Recommendation Report for Planning Permission for Works or Extension to a Dwelling

REF NO: R/42/26/HH

LOCATION: 9 Harsfold Road
Rustington
BN16 2QE

PROPOSAL: Single storey rear extension, new open porch with single-storey extension to existing garage.

Rev.	Notes	Date
 NAT DESIGN ARCHITECTURAL SERVICES M: 07599199759 E: info@nat-design.co.uk www.nat-design.co.uk		
Project		
9 Harsfold Road, Rustington, BN16 2QE		
Drawing		
Proposed Site & Roof Plans		
Drawn By NSE		Scale as shown
Date Feb 2026		Revision
Drawing No. 2035 -DPA - 02

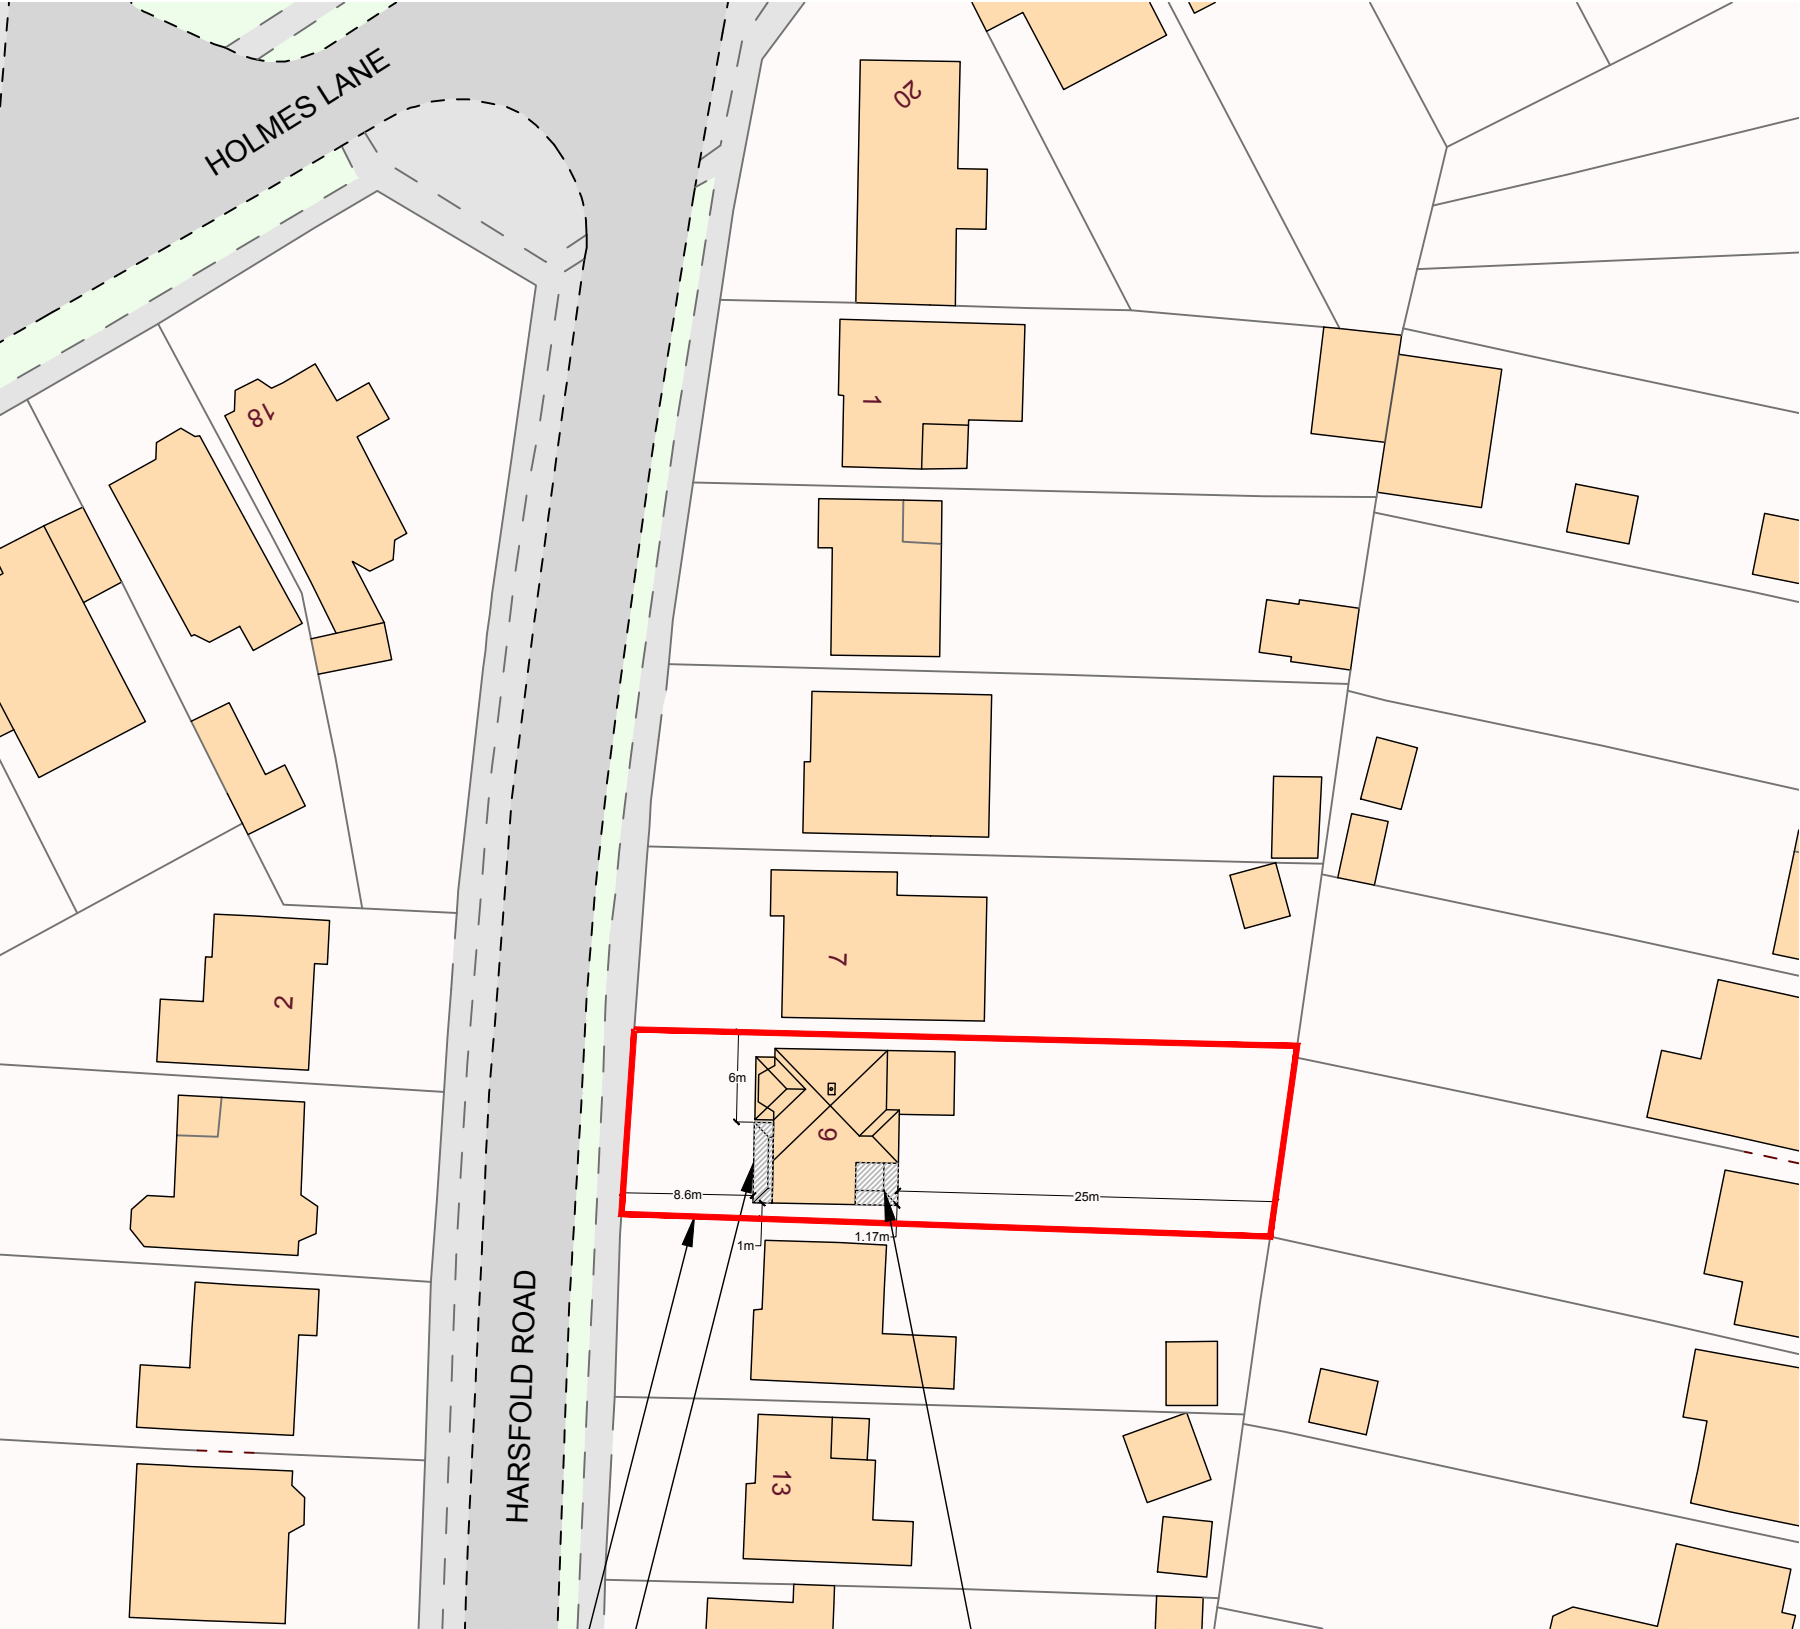
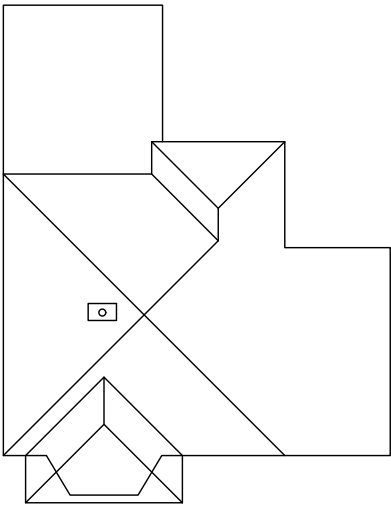
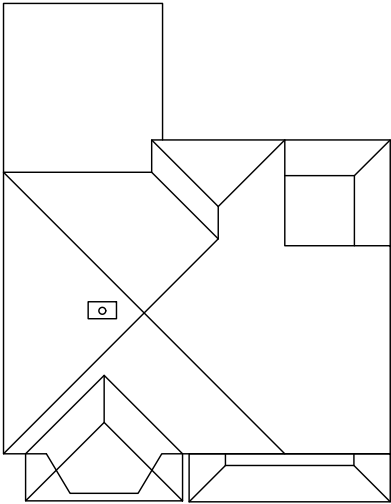
The front extension and porch would be positioned approximately 1m from the southern side boundary and would marginally project beyond the built line of the neighbouring dwelling to the south. The depth of the extension would accord with the ADG and, given its modest scale and the separation distances involved, it would not result in overbearing or overshadowing impacts to the neighbouring property.

To the north, the development would be set in approximately 6m from the side boundary and would be partially screened by the existing bay window projection. As such, no overbearing or overshadowing effects would arise to the neighbouring dwelling to the north.

The rear extension would retain a separation distance of approximately 1.1m from the southern boundary, consistent with the existing garage arrangement. The extension would not project beyond the built line of the neighbouring dwelling to the south and would therefore not result in overbearing or overshadowing impacts.

Rev.	Notes	Date
 NAT DESIGN ARCHITECTURAL SERVICES M: 07599199759 E: info@nat-design.co.uk www.nat-design.co.uk		
Project		
9 Harsfold Road, Rustington, BN16 2QE		
Drawing		
Existing & Proposed Floor Plans		
Drawn By NSE		Scale as shown
Date Feb 2026		Revision
Drawing No.		
2035 -DPA - 03

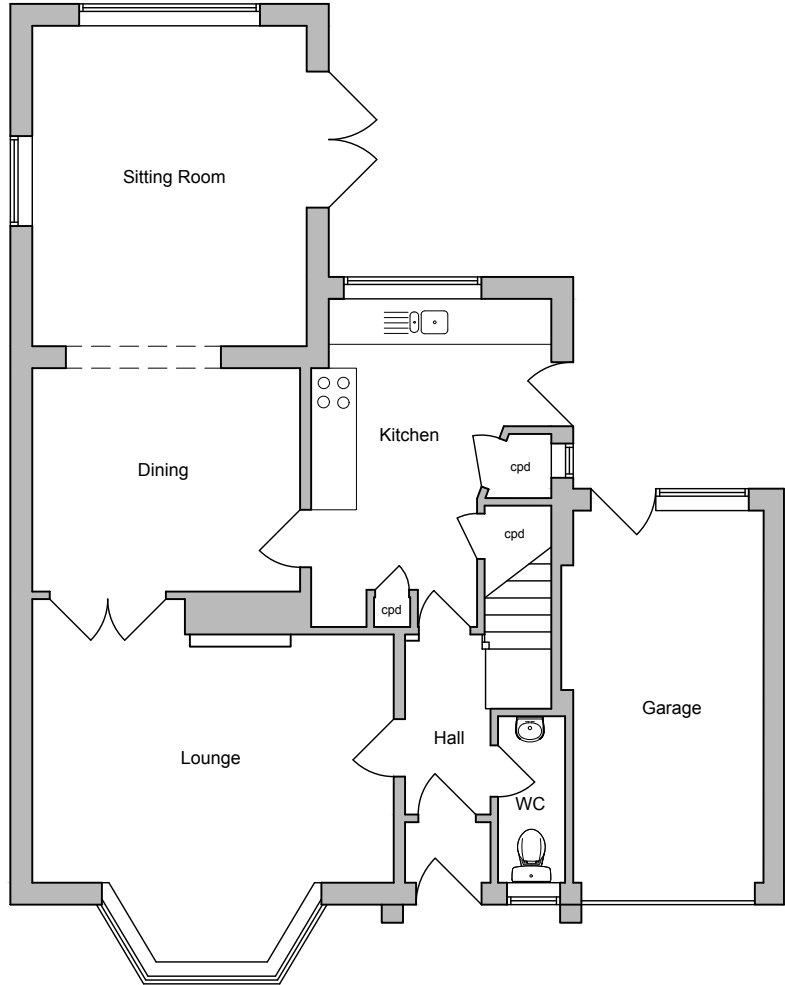
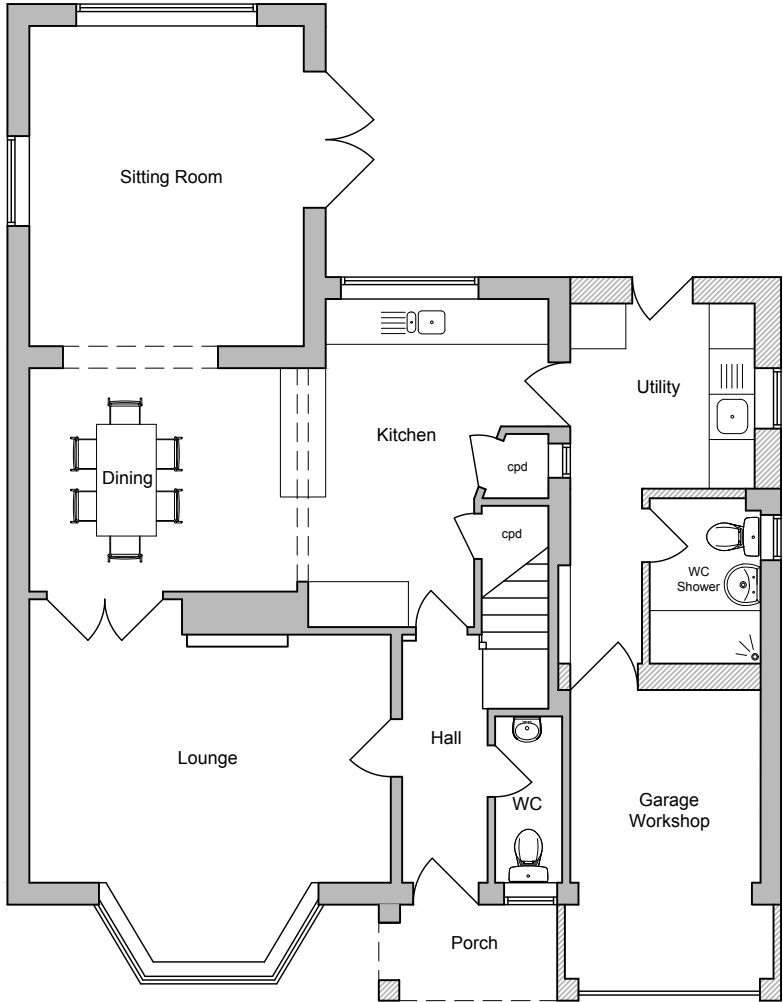
The garage extension would project approximately 1.3m forward of the front elevation, maintaining an overall width of approximately 2.9m. The extended garage would adjoin the rear extension, forming an overall depth of approximately 8.3m. Internally, the garage would be partitioned and reconfigured for use as a workshop to facilitate the proposed rear extension. Externally, it would feature a flat top hipped roof with a maximum height of approximately 3.2m and an eaves height of approximately 2.3m.

The site is within Parking Zone 4 and as per the Arun Parking Standards (APS), the dwelling is required to provide 2 parking spaces. Neither the existing nor the proposed garage would meet the best practice minimum internal dimensions for garages. The ADG states that garages should measure at least 6m by 3m internally to qualify as a parking space. As such, the proposed garage cannot be counted towards the parking provision.

Rev	Notes	Date
 M: 07599199759 E: info@nat-design.co.uk www.nat-design.co.uk		
Project:		
9 Harsfold Road, Rustington, BN16 2QE		
Drawing:		
Proposed Elevations		
Drawn by NSE		Scale as shown
Date Feb 2026		Revision
Drawing		
2035 - DPA - 05

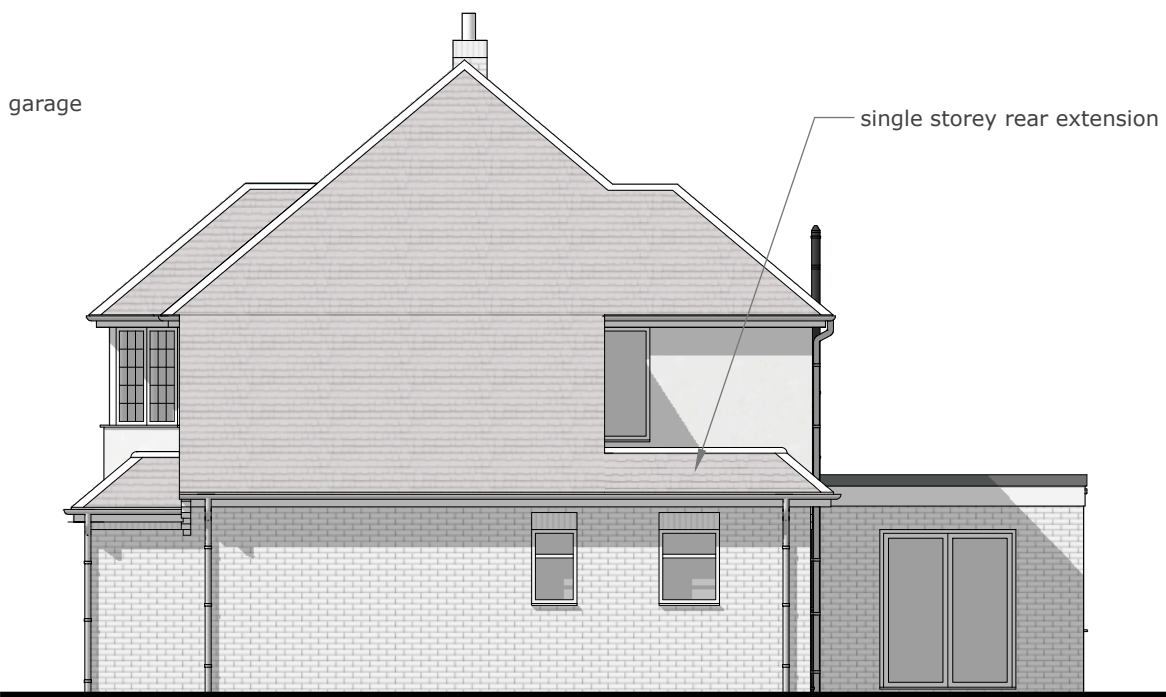
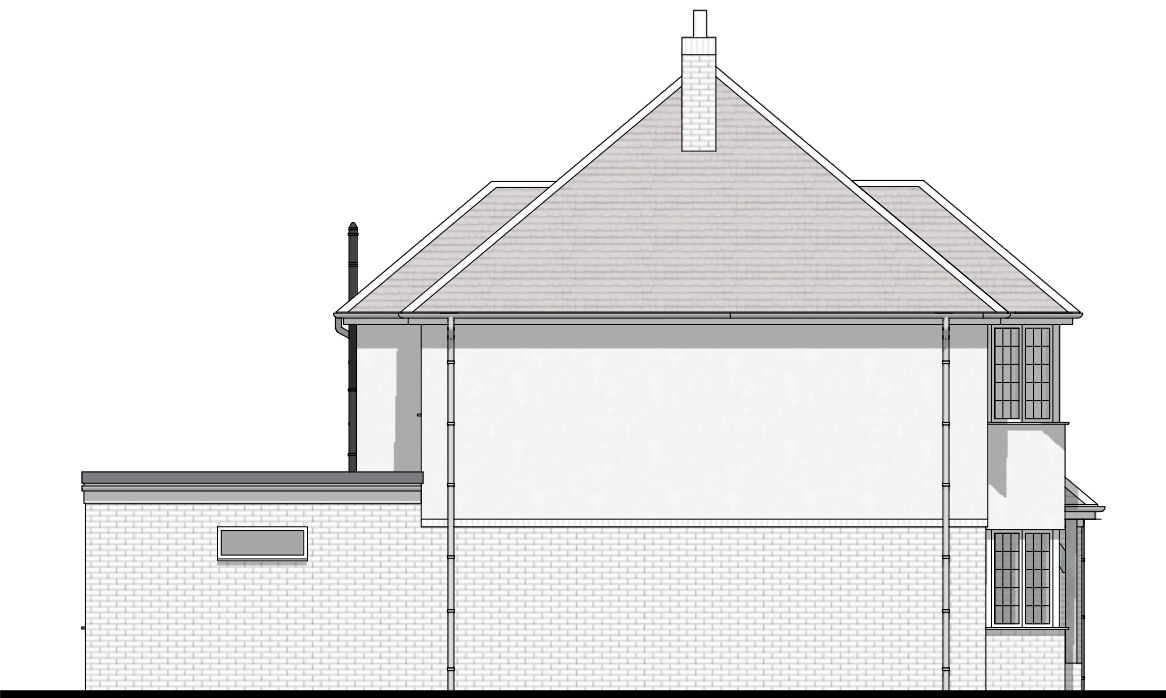
An open front porch is proposed adjacent to the garage extension, incorporating an oak post and brick pier, and finished with the same roof form. Both front projections would be constructed in brickwork and roof tiles to match the existing dwelling, ensuring visual continuation of the existing building design in accordance with the Arun Design Guide (ADG).

The existing fenestration would largely remain unchanged, with the exception of alterations to the front entrance door. The garage door would remain as a rolling shutter door.

The rear (east) extension would measure approximately 2.8m in depth and 2.8m in width, infilling the space between the existing rear projection. It would feature a flat top hipped roof with a maximum height of approximately 3.2m and an eaves height of approximately 2.5m. The extension would be constructed in matching brickwork and roof tiles to ensure visual integration with the dwelling, in accordance with the ADG.

Proposed fenestration would include two sash windows within the south elevation and a patio door within the rear elevation, providing access to the private amenity space.

Two new windows are proposed within the south elevation of the rear extension. These would be at ground-floor level, with a flank to flank separation distance of approximately 2.6m to the neighbouring dwelling. Given their ground-floor position and the separation distance, the windows would not result in overlooking or a loss of privacy.
